## WEST SUSSEX COUNTY COUNCIL CONSULTATION

| <b>FROM:</b>                    | WSCC - Highways Authority                                                                                                                             |
| <b>DATE:</b>                    | 8 October 2020                                                                                                                                        |
| <b>SUBJECT:</b>                 | A/151/20/OUT<br><br>Outline application for all matters reserved for the erection of 1 No. detached dwelling with associated landscaping and parking. |

Indicative Site Layout

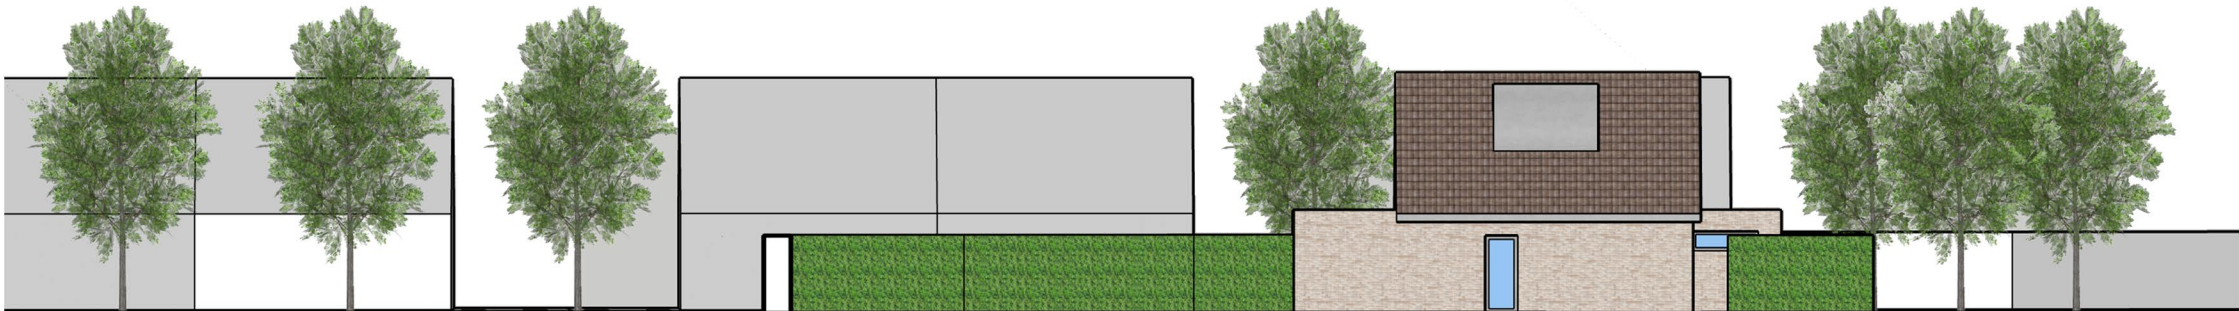
The applicant and the LPA should be made aware that the proposal will see the siting of a building within the Highway Boundary.

Prior to commencement, the Public Highway in question must first be 'Stopped Up' and have its highway rights extinguished.

The Local Planning Authority and the applicant should be mindful that the WSCC Highways Area Office, whom is responsible for the issuing of VCO Licenses, do not wish to see VCO's measuring over 6.4 metres. While this is not a highways safety issue the LHA wish that good planning practices are kept and as such, no planning application is permitted where it cannot be implemented. As a result, the LHA advises the applicant at the reserved matters stage, shows a VCO no greater than 6.4 metres.

At the reserved matters stage, the Local Highways Authority (LHA) advise the applicant to provide maximum achievable visibility splays for both the proposed access points. This will allow the LHA to judge if the proposed access is substandard.

All Visibility splays must include a 2.4m setback distance from the kerb edge of the footway and span in both directions to the kerbed edge. The splays must not intersect third party land, be located solely within land under the control of the applicant or within the Publicly Maintained Highway and include the current road geometry. We have provided a diagram below for your guidance only.

The applicant should be aware that for the LHA to consider vehicle parking spaces towards the parking provision of the dwelling they should measure no less than 2.4 x 4.8 metres.

A turn on site is preferred where possible. This should allow all spaces to be accessed. The LHA considers 6 metres to the rear of any parking space adequate to perform such a manoeuvre.
